Recommendation Report for Planning Permission

REF NO: A/31/19/PL

LOCATION: Land between Ashurst & Badgers
Ham Manor Way
Angmering
BN16 4JQ

PROPOSAL: 1 No. two storey house (resubmission following A/87/18/PL). This application is a Departure from the Development Plan & affects a Public Right of Way.

Drawing Title:
Proposed Plans, Elevations and Street
Scene Elevation
Drawing Number: 1202.01.c
Scale: As stated printed @ A1
Date: 06/02/2019

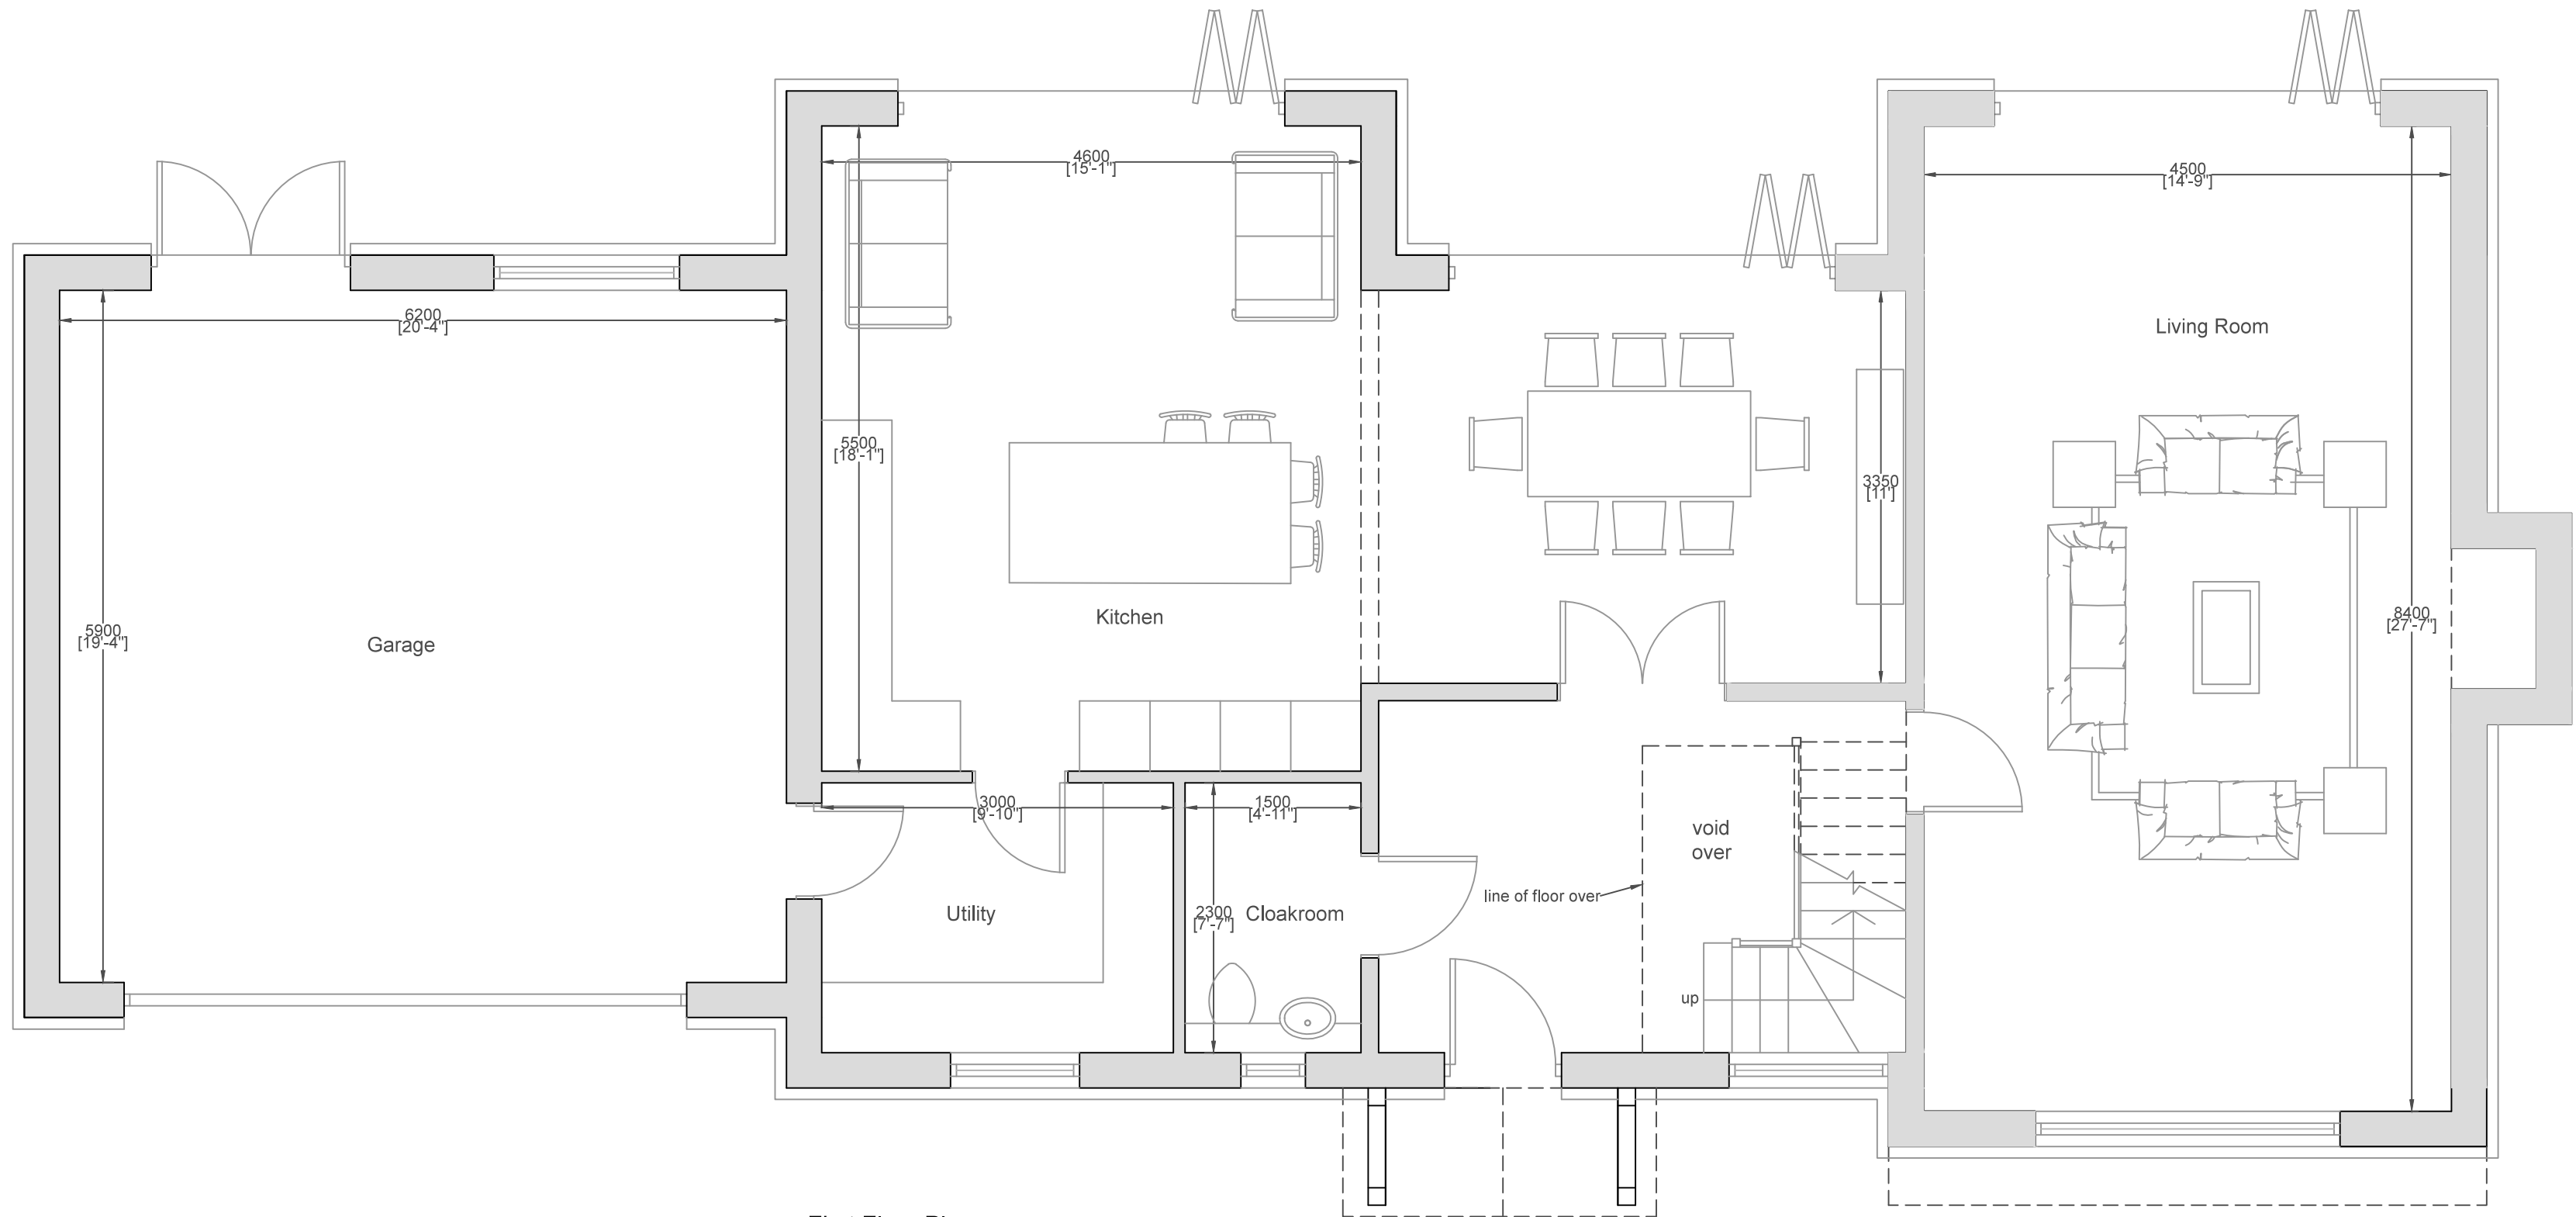
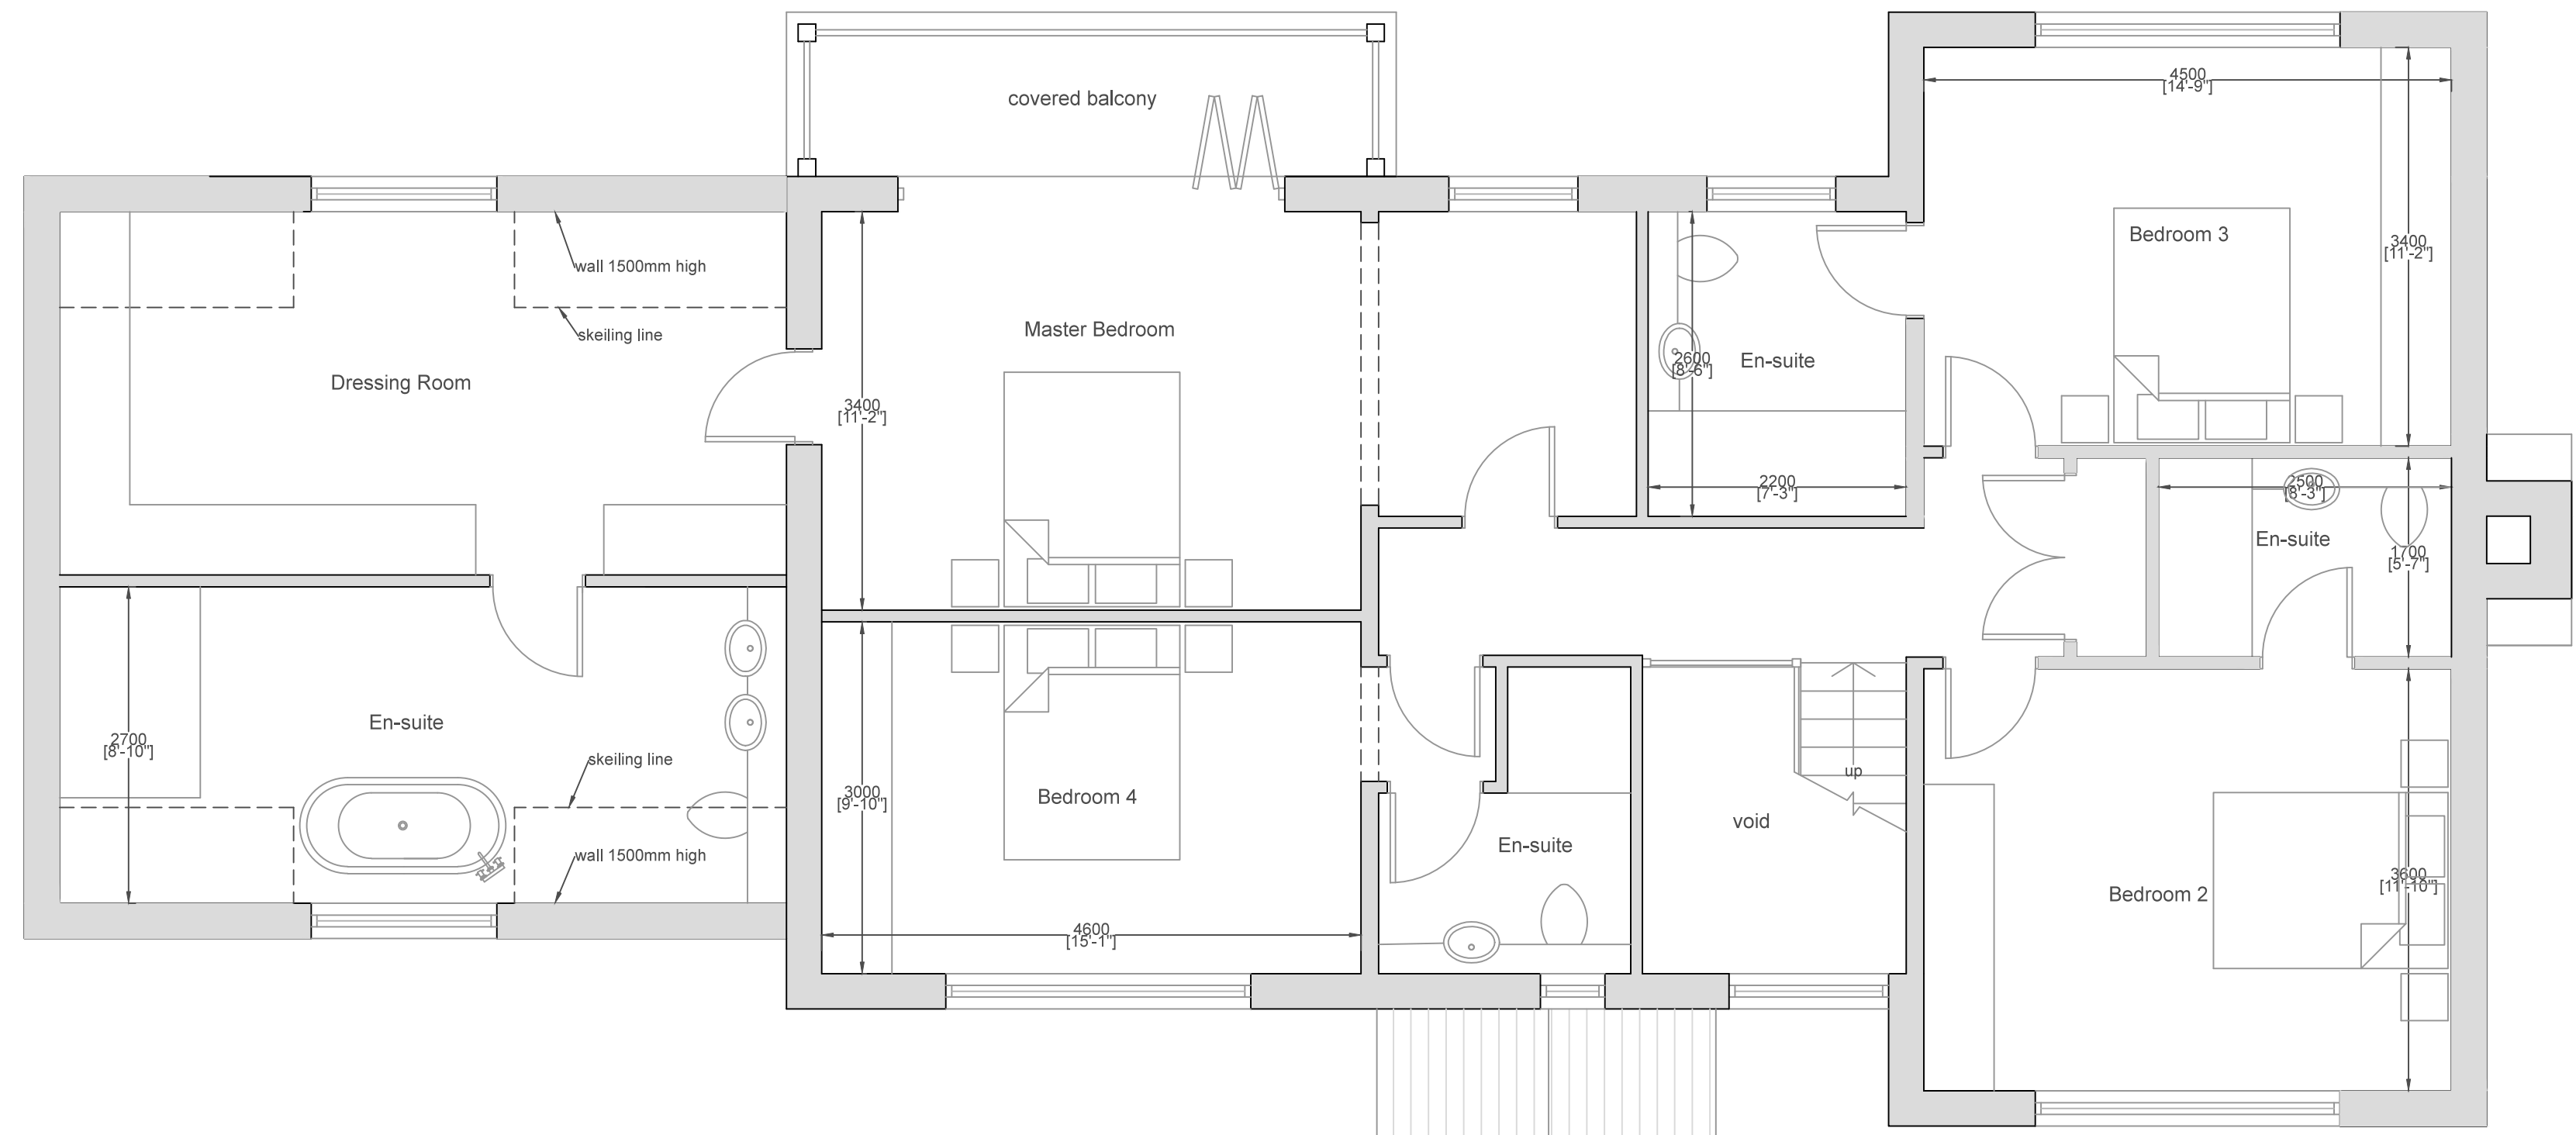
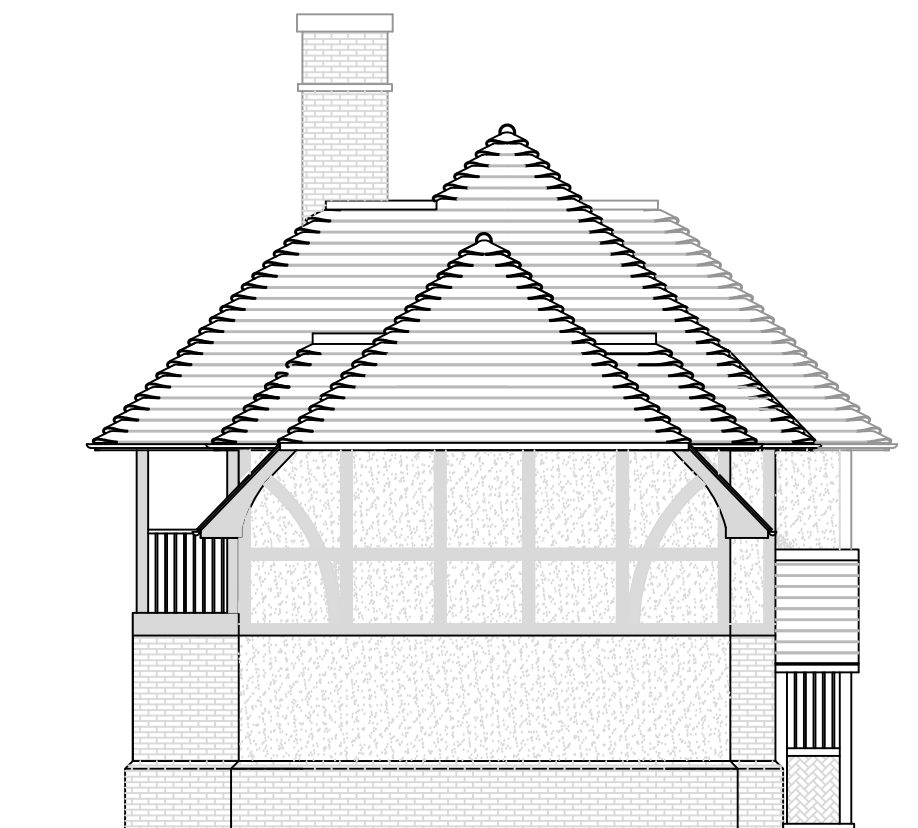
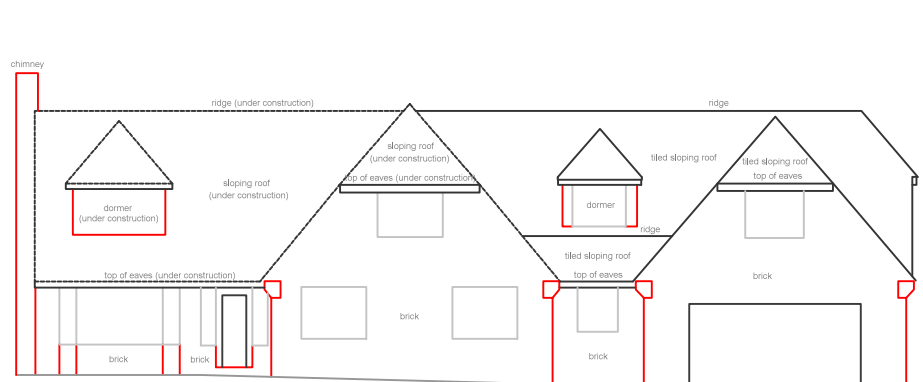
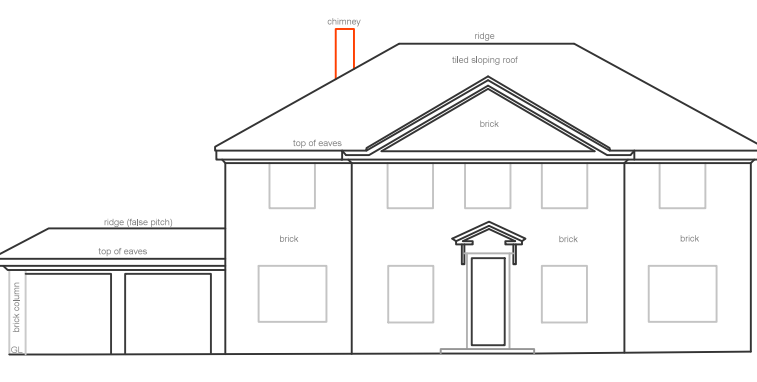
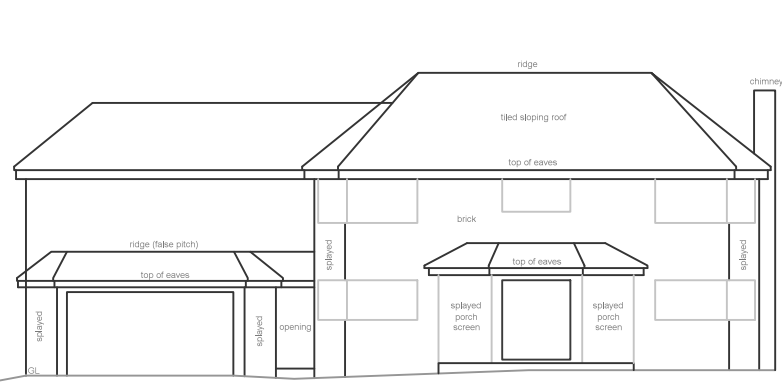
Whilst the dwelling is large and is close to the north eastern boundary it will provide a significant garden area to the south and is set back on the site in a similar position to adjacent dwellings. The gaps to the northern boundary is similar to other properties on the estate and would allow for adequate boundary screening and planting. In terms of dwelling to plot ratio it is considered to be in keeping. The similar position in respect of the set back from the road frontage and replication of the pattern of adjoining development ensure that although the dwelling is large it is not significantly dissimilar in size and plot coverage to other dwellings along Ham Manor Way.

The proposed materials are not precisely specified on the elevation plans. Clay tiles to the roofs and face brick work elevations would accord with the materials on other properties in Ham Manor Way, but precise details would need to be controlled by condition. The design, appearance and form of the dwellings generally would reflect other properties fronting Ham Manor Way which is characterised by large detached mainly 2 storey dwellings of varying design and style. The height of the dwelling and plot depth would be directly comparable with the neighbouring property to the south. The property design is

traditional and the use of differing materials provides visual interest. In this respect the proposal would accord with policies HD5 and HD6 of Angmering Neighbourhood Plan and meets the standard of design referred to in policy DDM1 of Arun Local Plan. However whilst the design of the dwelling is considered acceptable the proposal would adversely affect the character of the area and is therefore contrary to policy.

The proposal would not adversely impact on the residential amenities of adjoining properties. No windows are proposed at first floor or above in the side elevations.
